Reference	Y/15/17/DOC
Status	Undecided
Proposal	Application for approval of details reserved by condition imposed under Y/64/16/PL relating to conditions 5-landscape scheme for HGV parking site, 6-landscape scheme along southern boundary, 7-Site Management Plan & 10-light appliances.
Location	Land to the North of John Turner P Lake Lane Barnham PO22 0AL

After reviewing the proposed planting scheme provided by SLH, '**Landscaping and Planting Plan – John Turner Phormiums FINAL v1.PDF**' we wish to submit the following comments:

Additional planting plan for Stuart Lyons Haulage Depot for noise mitigation:

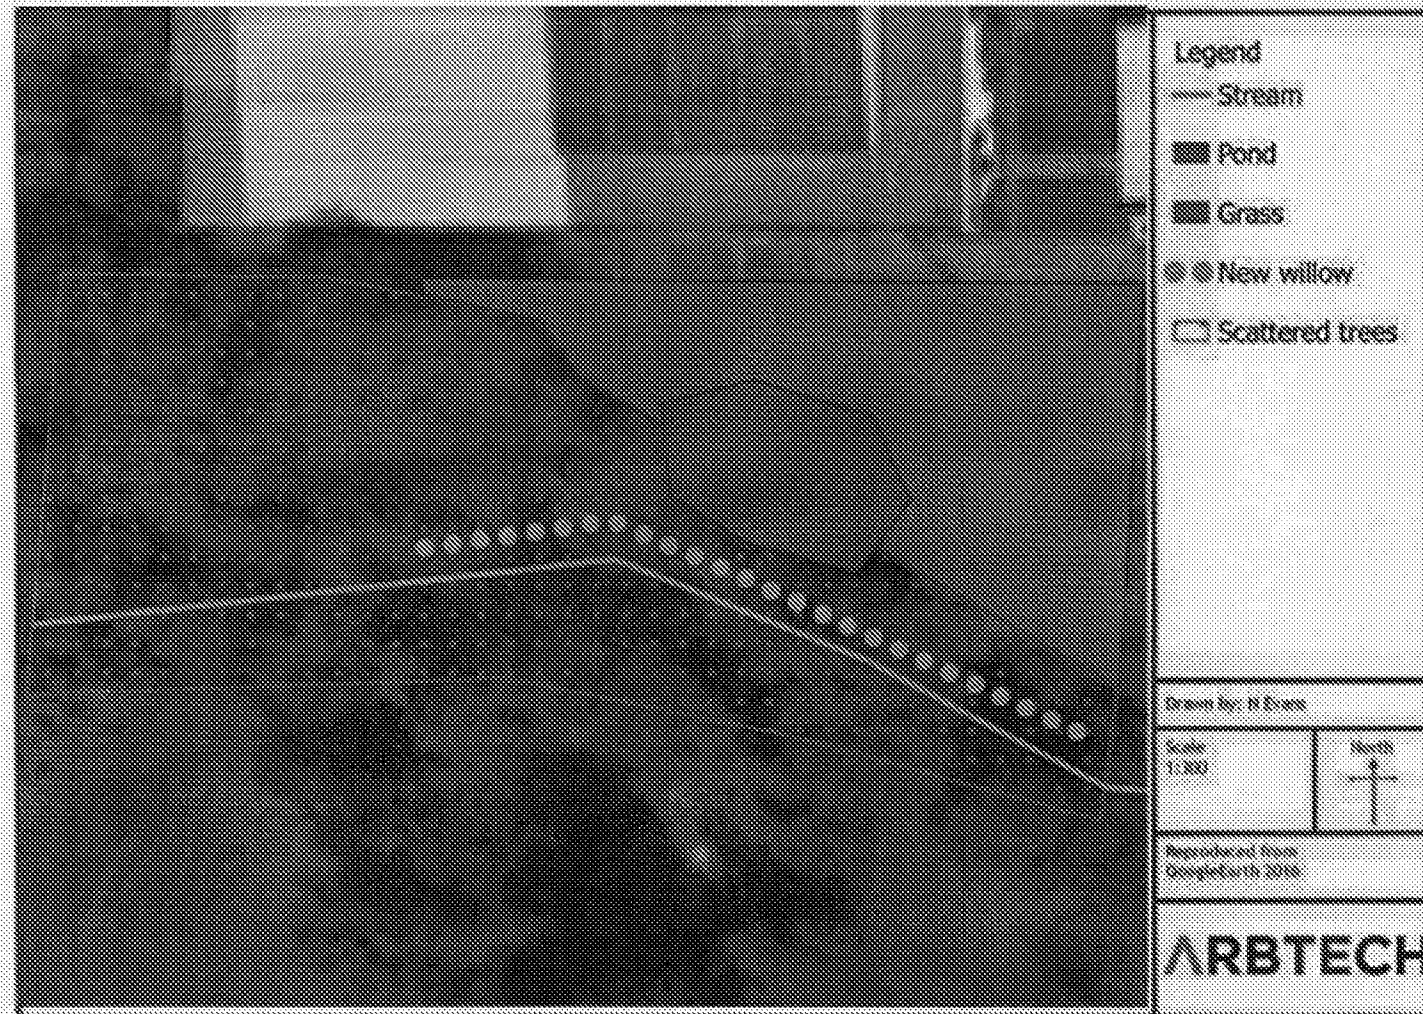
Comments

- 1) The 40m stretch in question above starts to the west after our property finishes; how will this provide further noise mitigation for the amenity and enjoyment of our house and garden, and to what levels?
- 2) Although a 40m stretch is quoted, the specification actually states a 'minimum' of 10 new trees will be planted, and goes on to reference them as 'cuttings'; how many trees will be planted, and how mature will they be at the time of planting?
